CITY OF ALBUQUERQUE

July 18th , 2024

Re: Bubba's 33
10000 Coors Blvd Bypass NW
Traffic Circulation Layout
 Engineer's/Architect's Stamp 07-11-24 (B14D004H)

**ACCESSIBLE PARKING SIGN DETAIL**

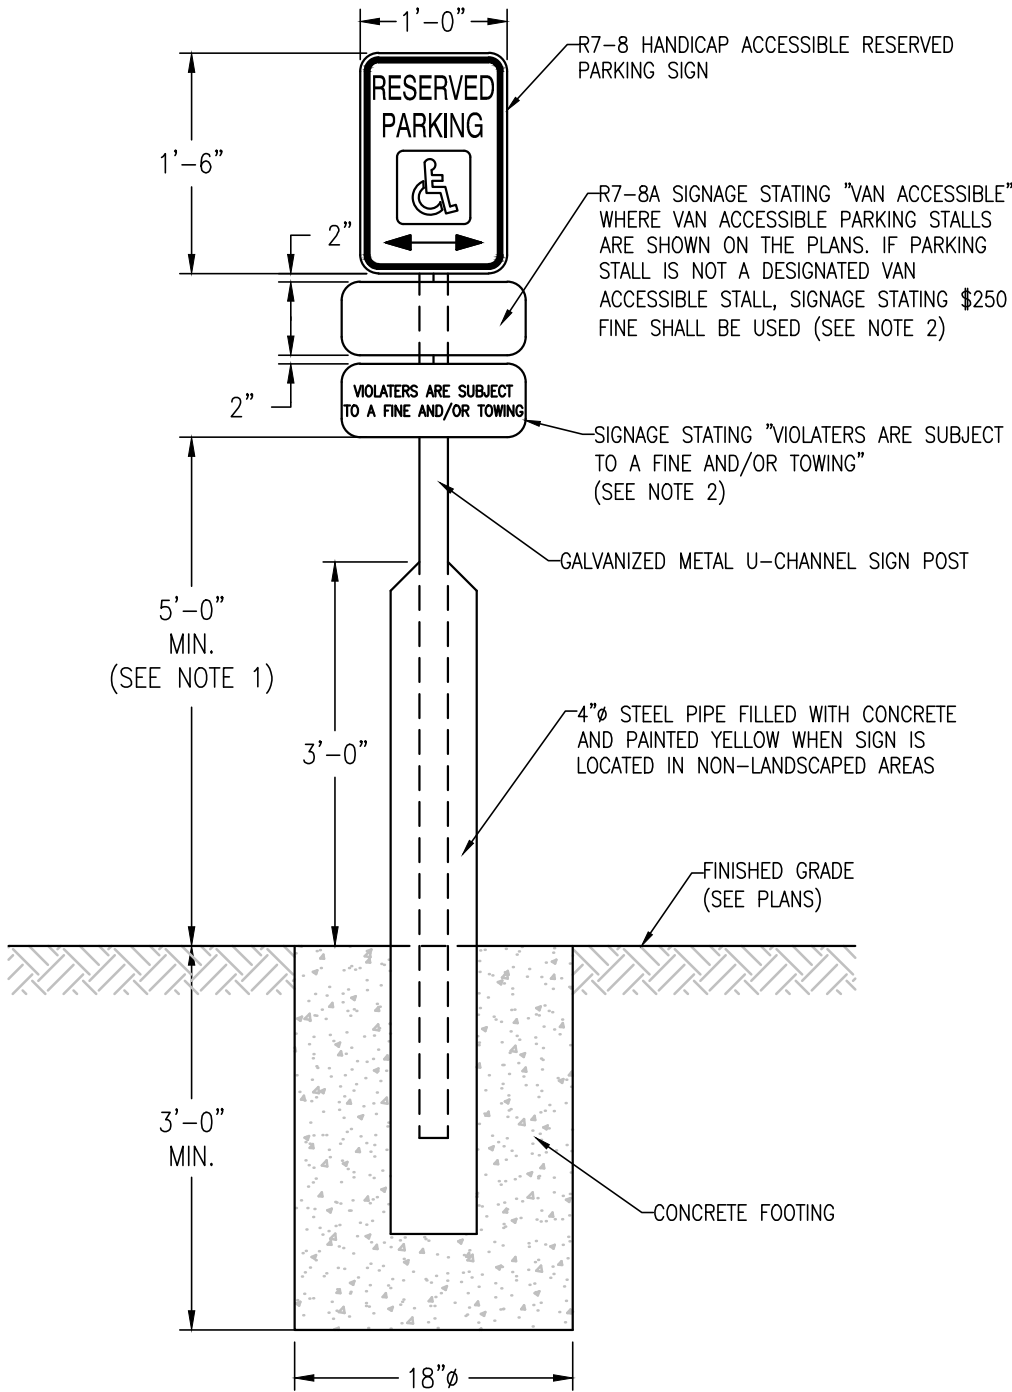
7. The ADA accessible parking sign must have the required language per 66-7-352.4C NMSA 1978 **"Violators Are Subject to a Fine and/or Towing."** Please call out detail and location of signs.
8. Bicycle racks shall be sturdy and anchored to a concrete pad. Show more details.
9. Show all drive aisle widths and radii. Some dimensions are not shown.

**ACCESSIBLE PARKING STALL DETAIL**

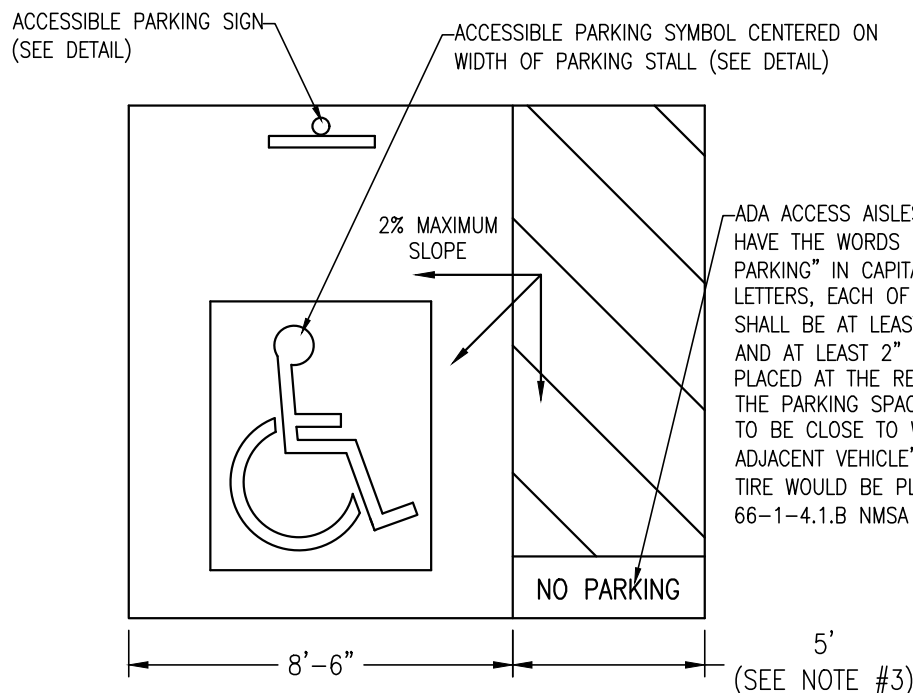
6. Show the dimension of Van accessible aisles in the ADA accessible spaces. Also clarify whether these aisles are flush with the ramp.
